From: [REDACTED]
Sent: 25 June 2026 13:33
To: Planning
Cc: Anna Robinson
Subject: Fw: Planning Application 3/2026/0413 - 7 Knowsley Road West

From: [REDACTED]
Sent: Sunday, June 21, 2026 5:39 pm
To: anna.robinson@ribblevalley.gov.uk <anna.robinson@ribblevalley.gov.uk>
Subject: Planning Application 3/2026/0413 - 7 Knowsley Road West

Proposed Ground Floor Plan
Scale (1:50)

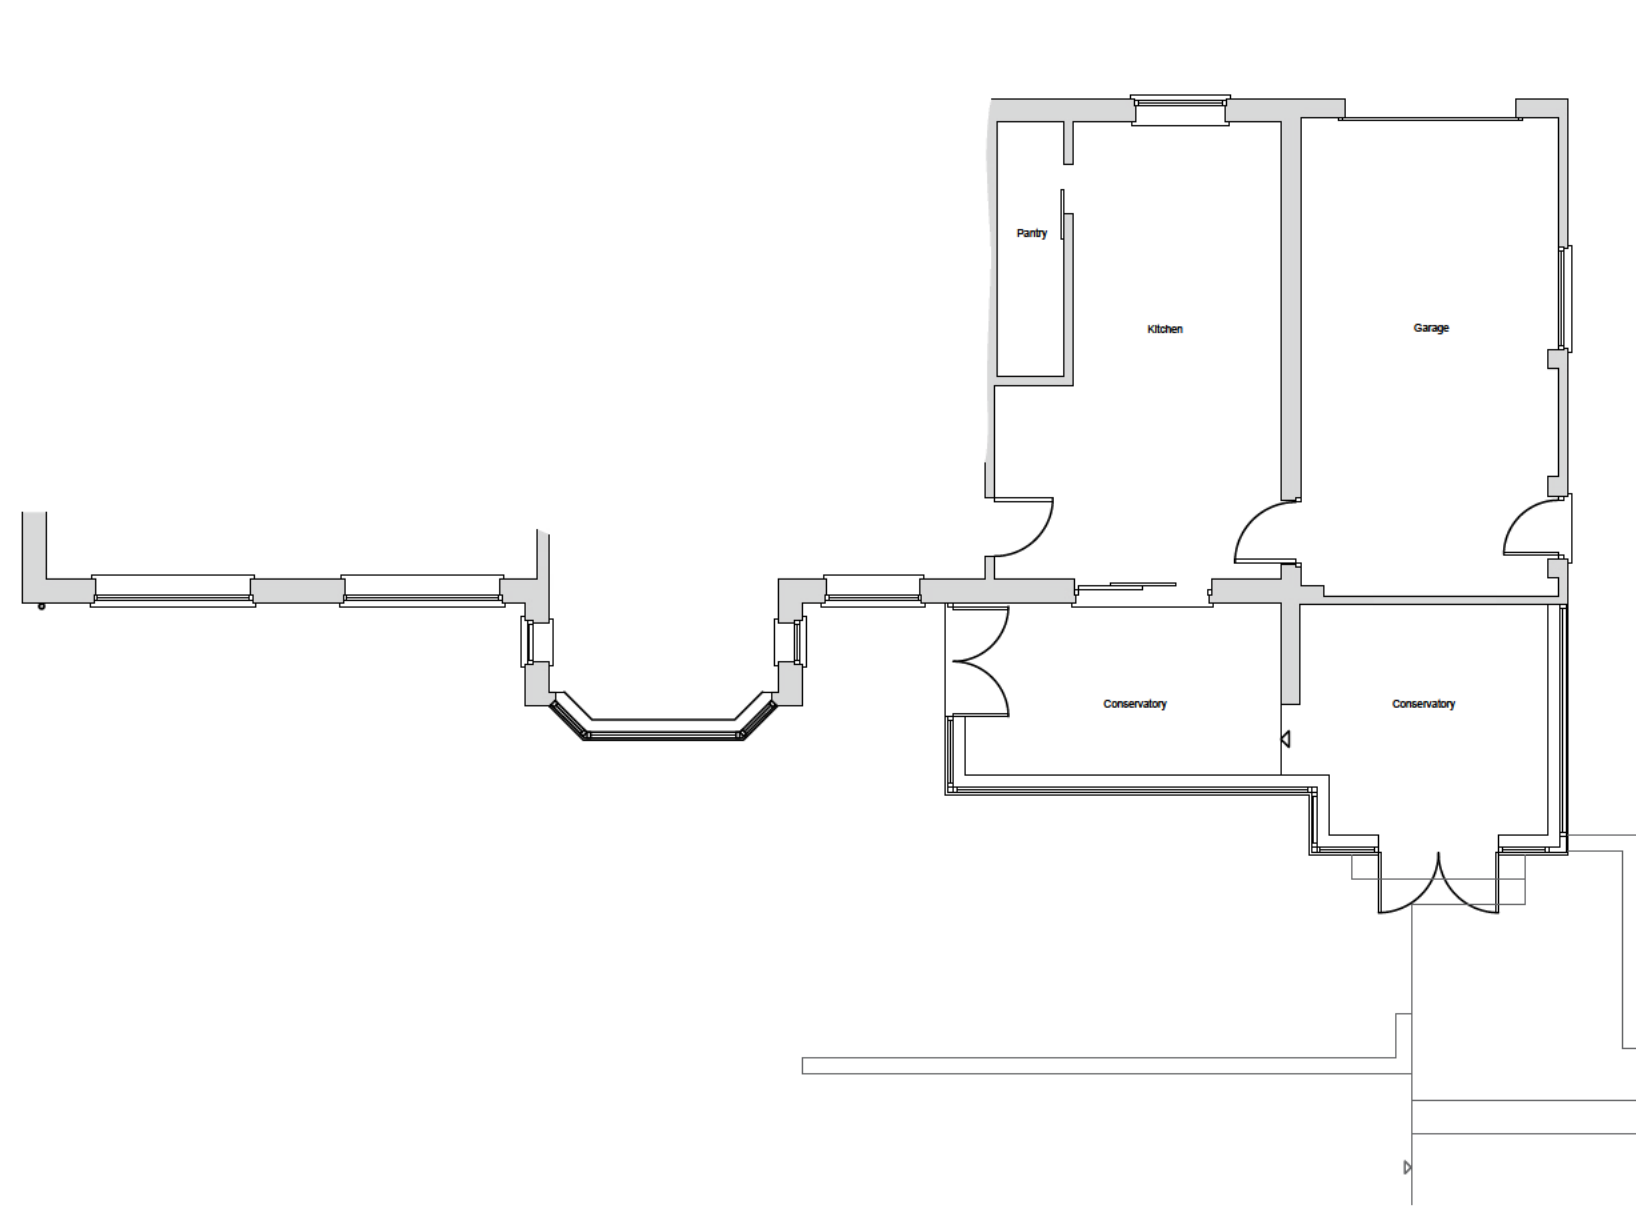
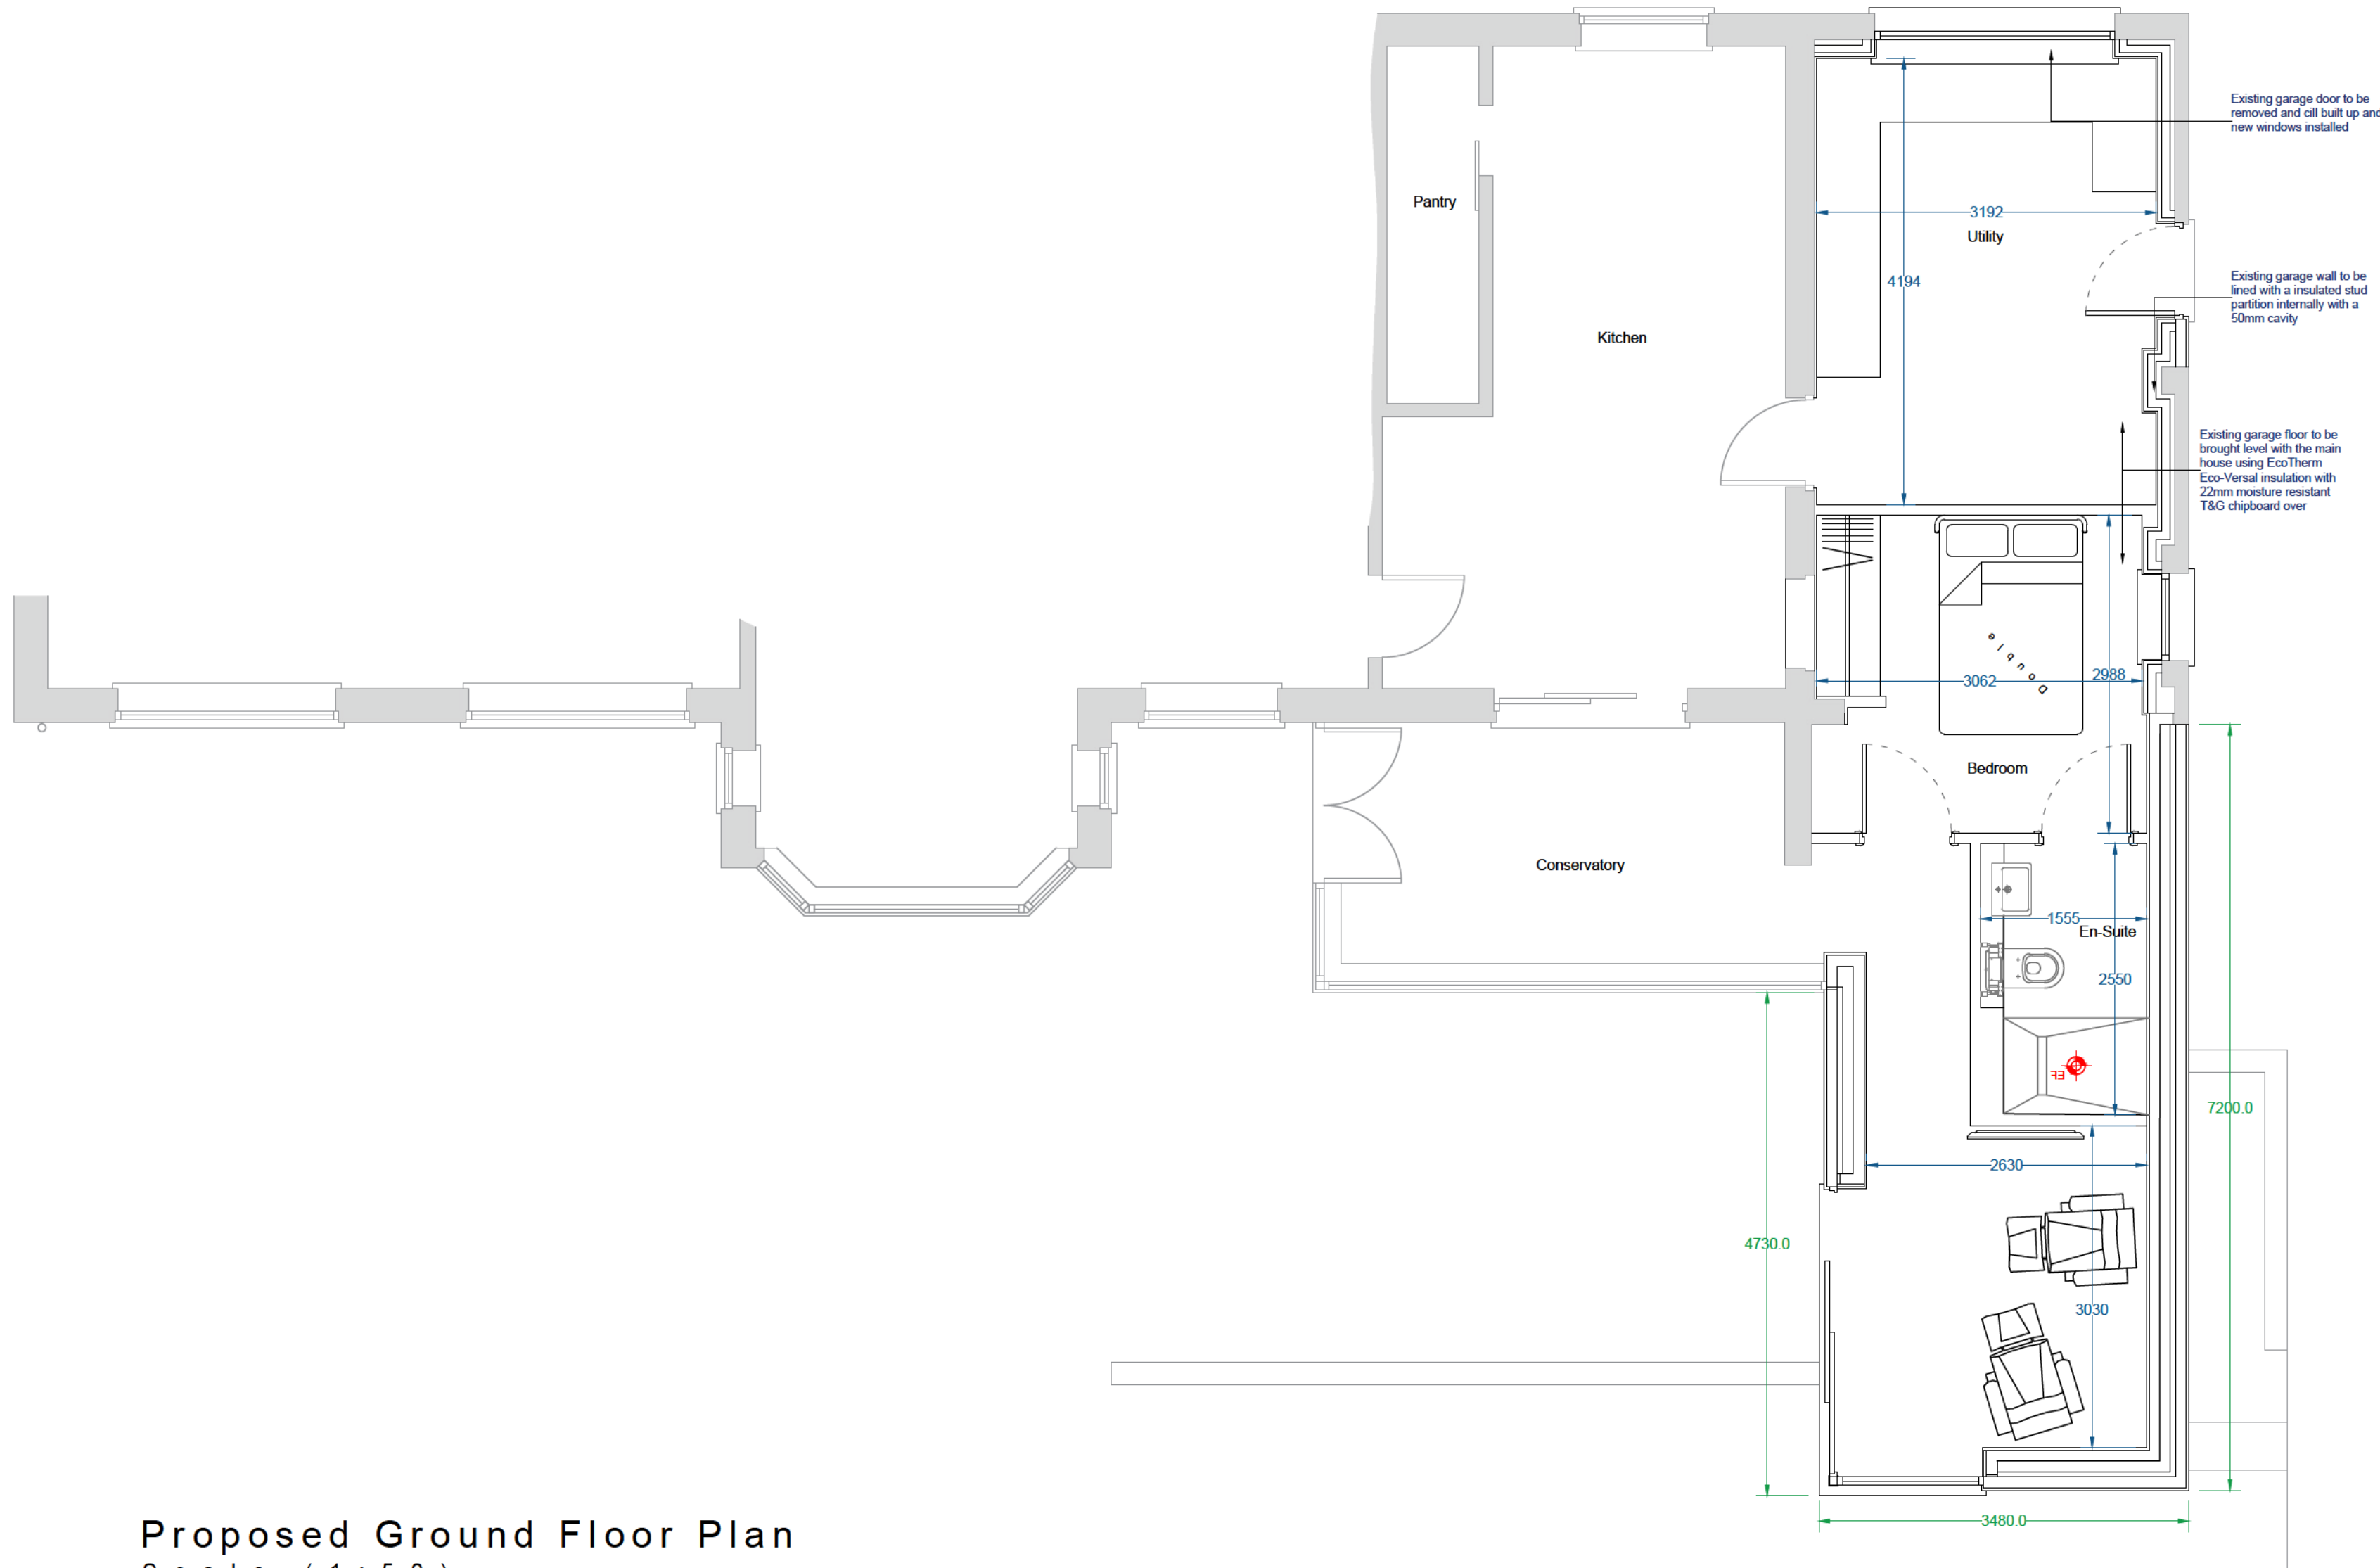
My understanding from the information available on the Council's website is that the proposed extension will extend 7.20 metres beyond the rear wall of the original dwelling house. This seems excessive and over dominant in terms of impact on the surrounding area. I am concerned that the extension will feel overbearing and have a negative visual impact. If approved this extension may subsequently be cited as an example of what is acceptable level of intrusion into garden areas when considering future similar applications.

I have received the neighbour notification letter in respect of the proposed development at 7 Knowsley Road West. I would be grateful if you could clarify whether the proposed extension will be

wider than the current footprint of the garage and conservatory as it isn't entirely clear from the information provided and available online. I am aware that there have already been approximately three extensions at 7 Knowsley Road West, is there any consideration given to the cumulative impact of previous extensions as part of the planning process.
